City of Albuquerque

CERTIFICATE OF COMPLETION AND ACCEPTANCE

RE: PROJECT NO. 4224.90, W & W FREIGHT - FIRE HYDRANT, (MAP NO. M-15)

RE: REVISED DRAINAGE PLAN FOR W & W FREIGHT
(M-15/D23A) REVISION DATED JUNE 29, 1990

GRADING AND PAVING PLAN

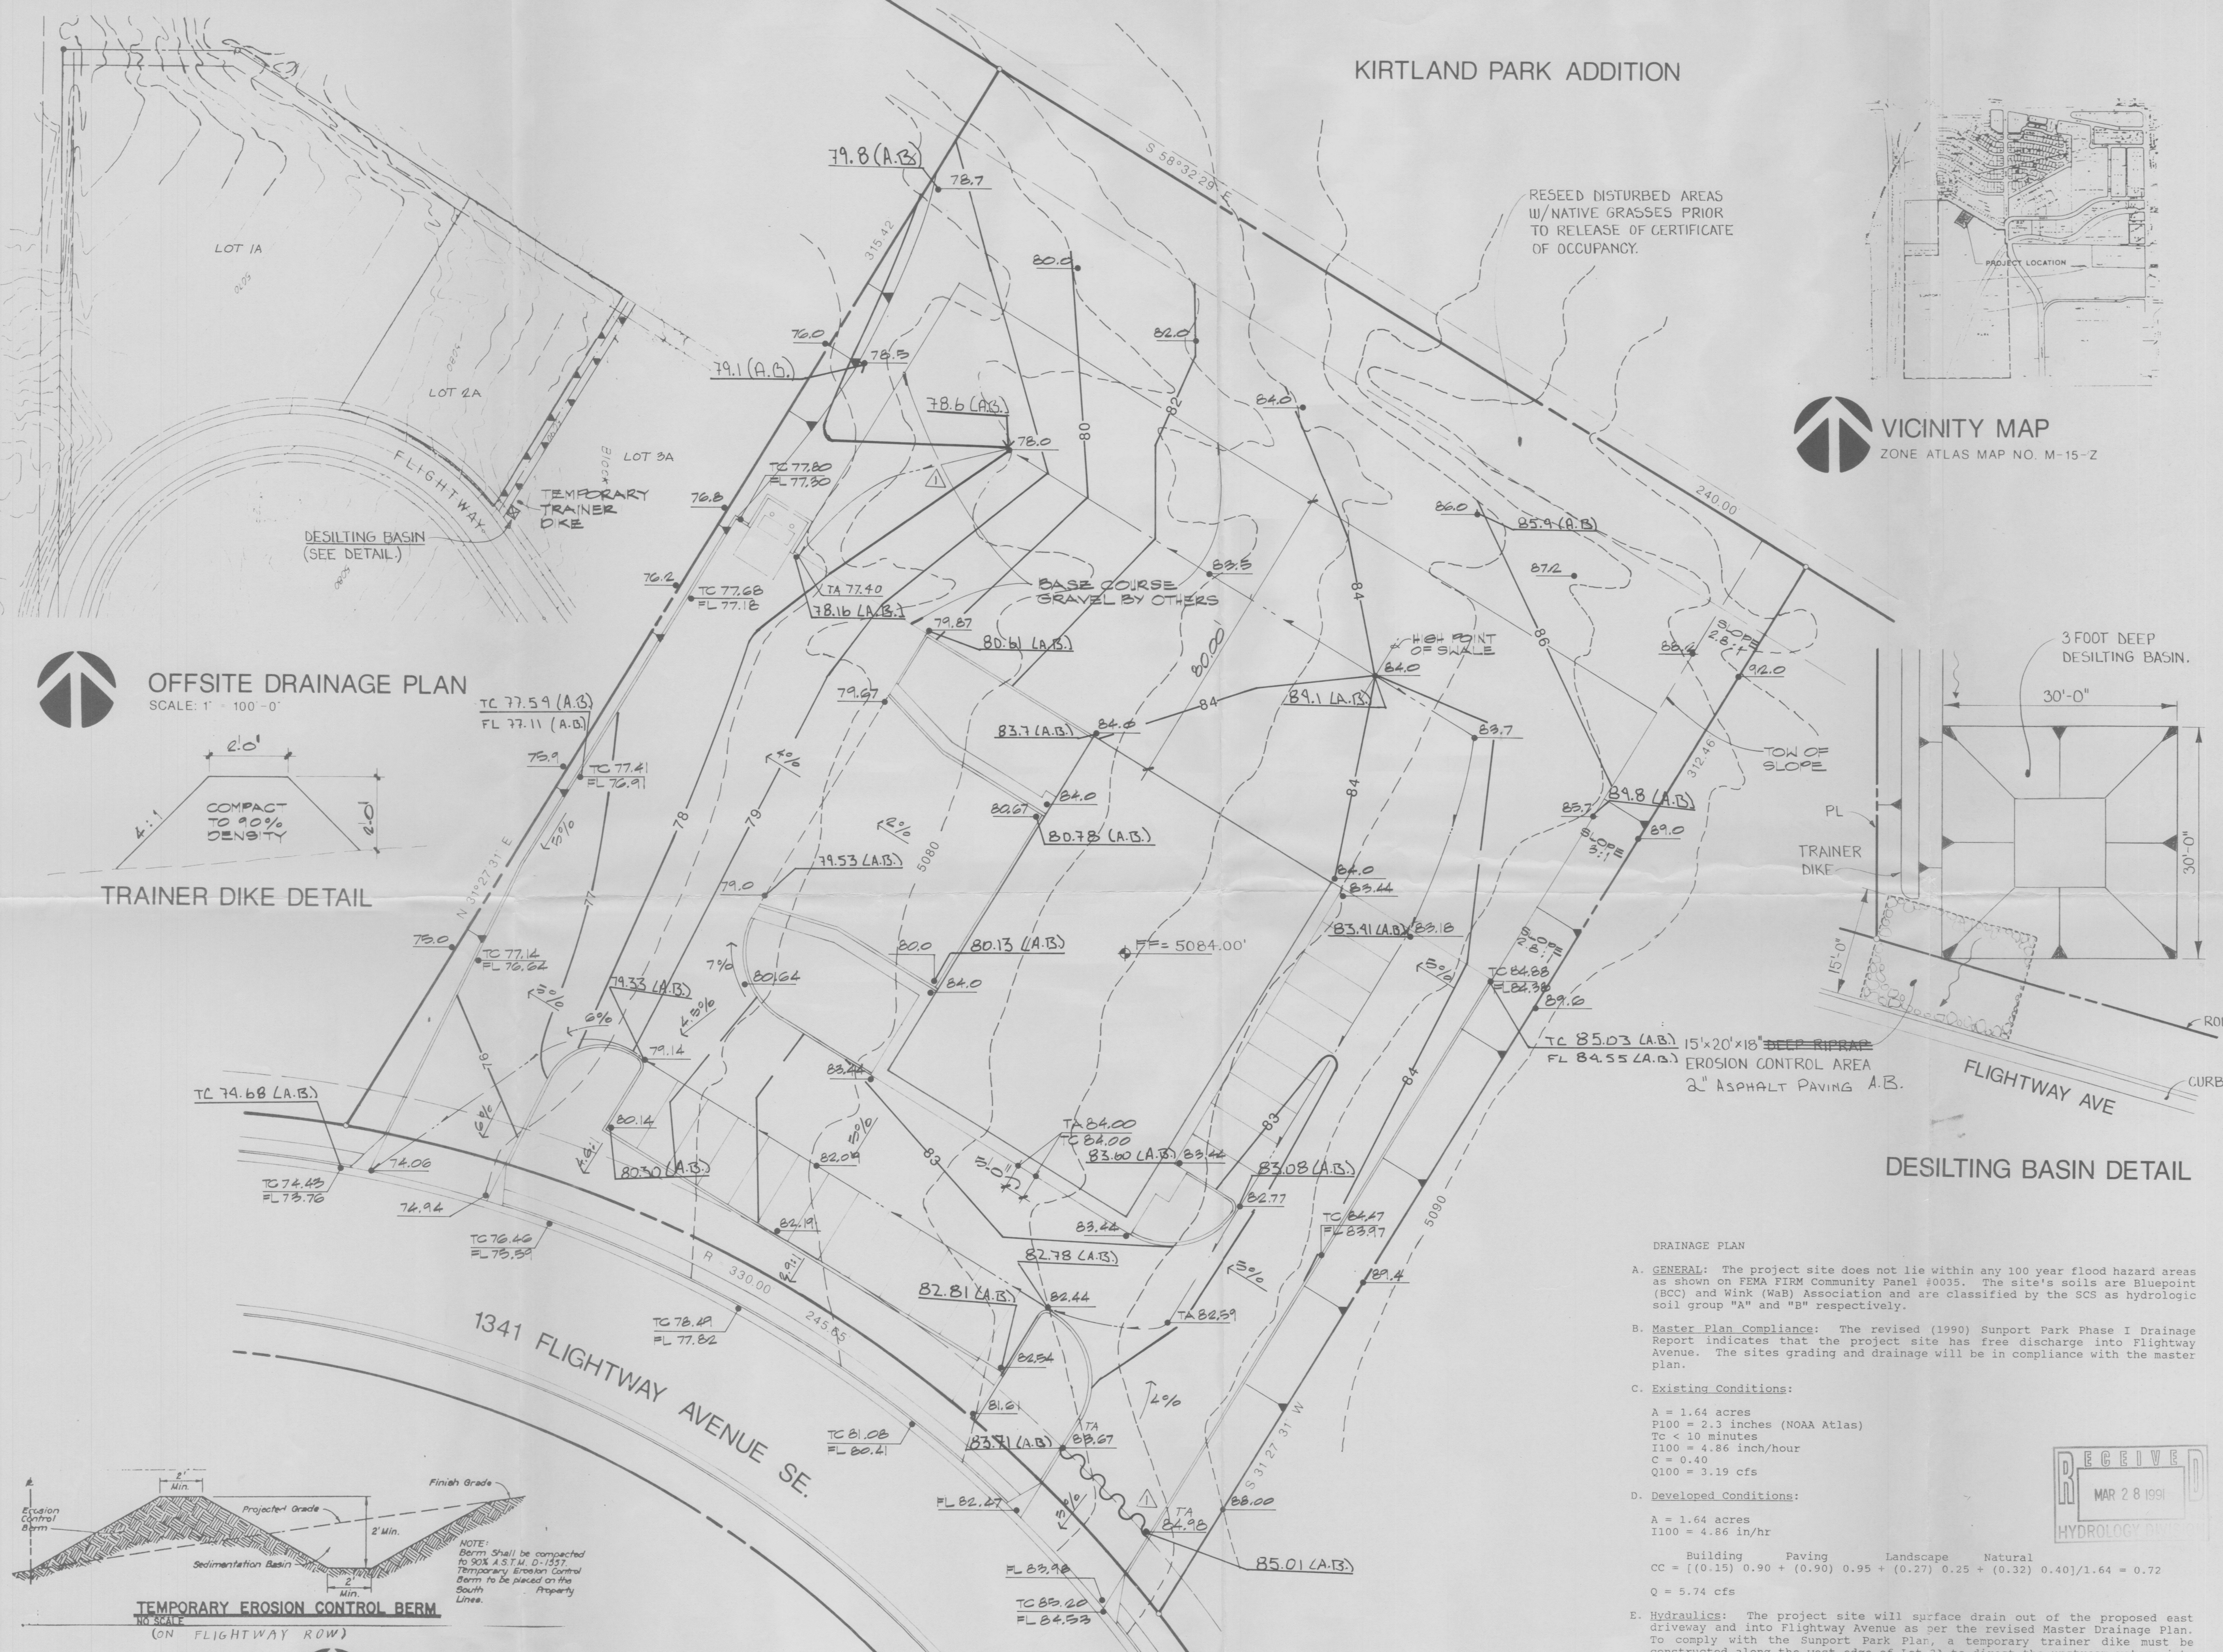
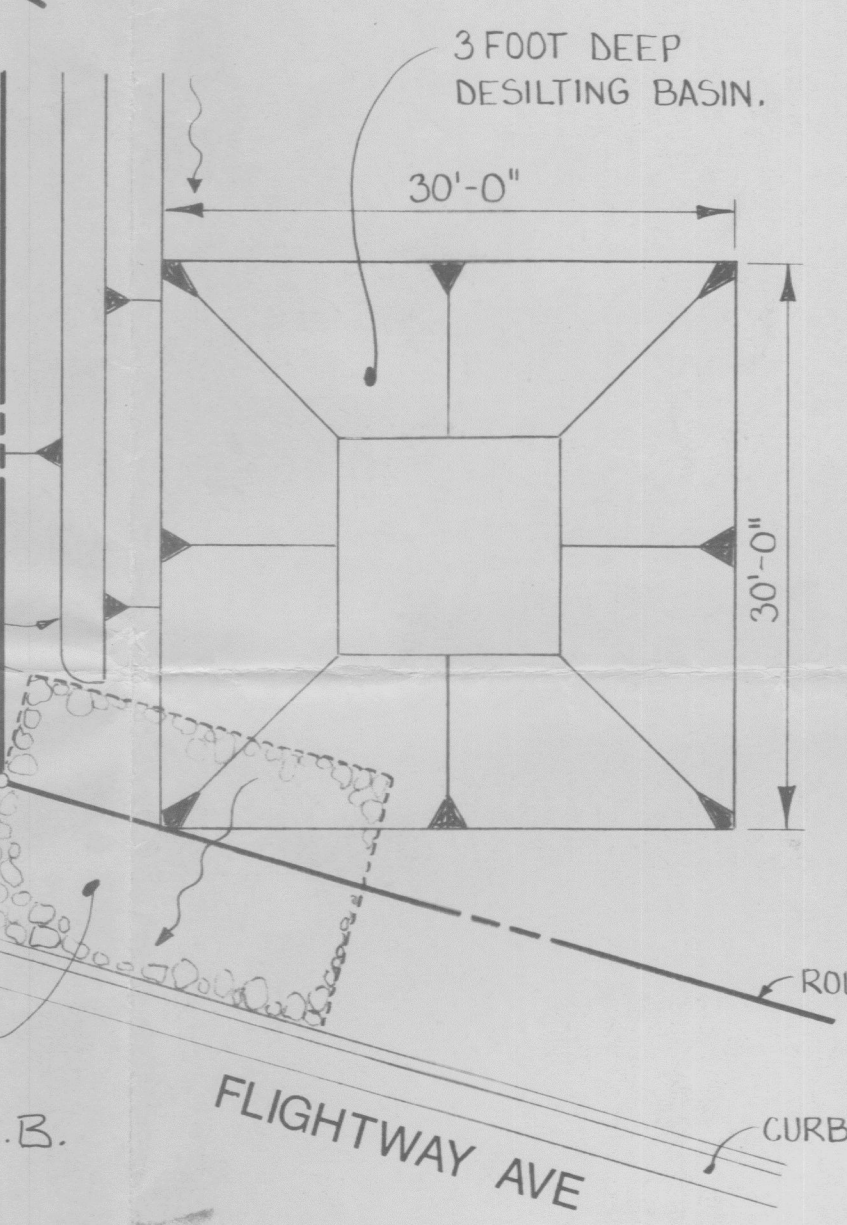
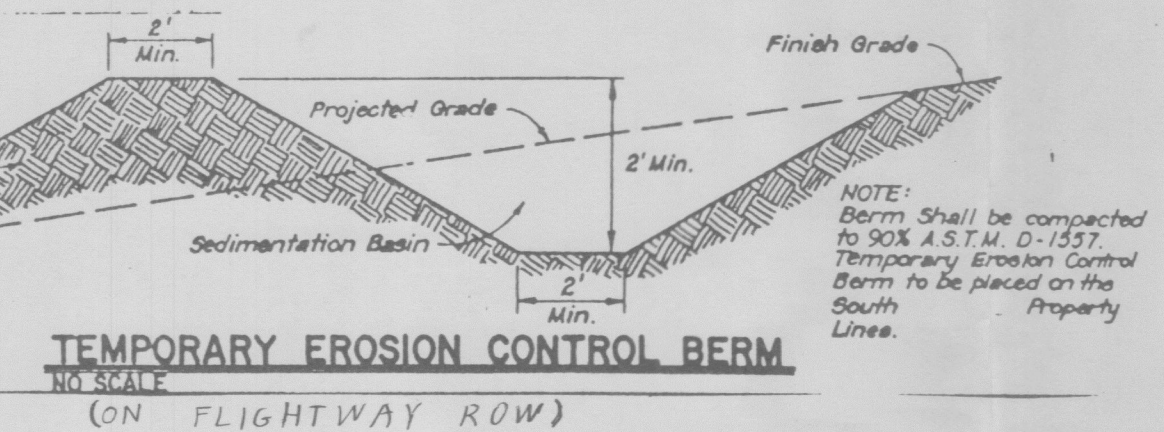
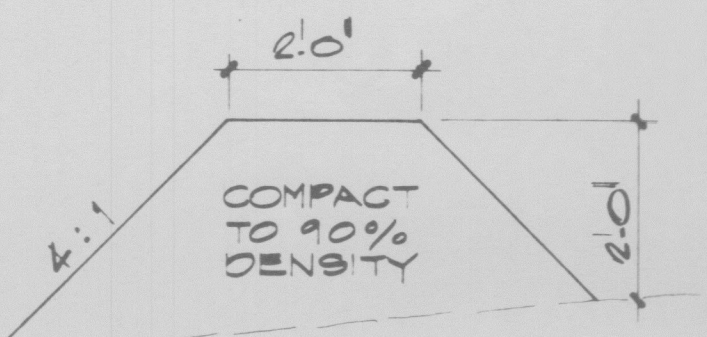
1. Revised master plan must identify street capacity prior to building permit release. One foot water block may not be sufficient.
2. The temporary trainer dike is located within Lot 2, which means that the following concerns apply.

- a. Permission to grade within Lot 2 from the appropriate land owner.
 - b. Maintenance agreement between the property owners identifying who is charged with the maintenance of the dike.

- c. What type of sediment control do you propose for the runoff being routed towards Flightway Avenue, SE from the proposed dike?
3. Finish floor elevation must be to full mean sea level.

4. Erosion control plan must be submitted for review and must be implemented immediately due to the rainy season and also because of the sediment problems experienced already.

5. Please show all calculations for computing the composite C using the Emergency Rule.
6. Please indicate the undeveloped flows.

7. The offsite flows of 1.4 cfs shown on the east side of the project.
How will the sediment be controlled from that area?
8. Reseeding schedule must also be submitted.
9. Please include a permanent T.B.M. within the site area.
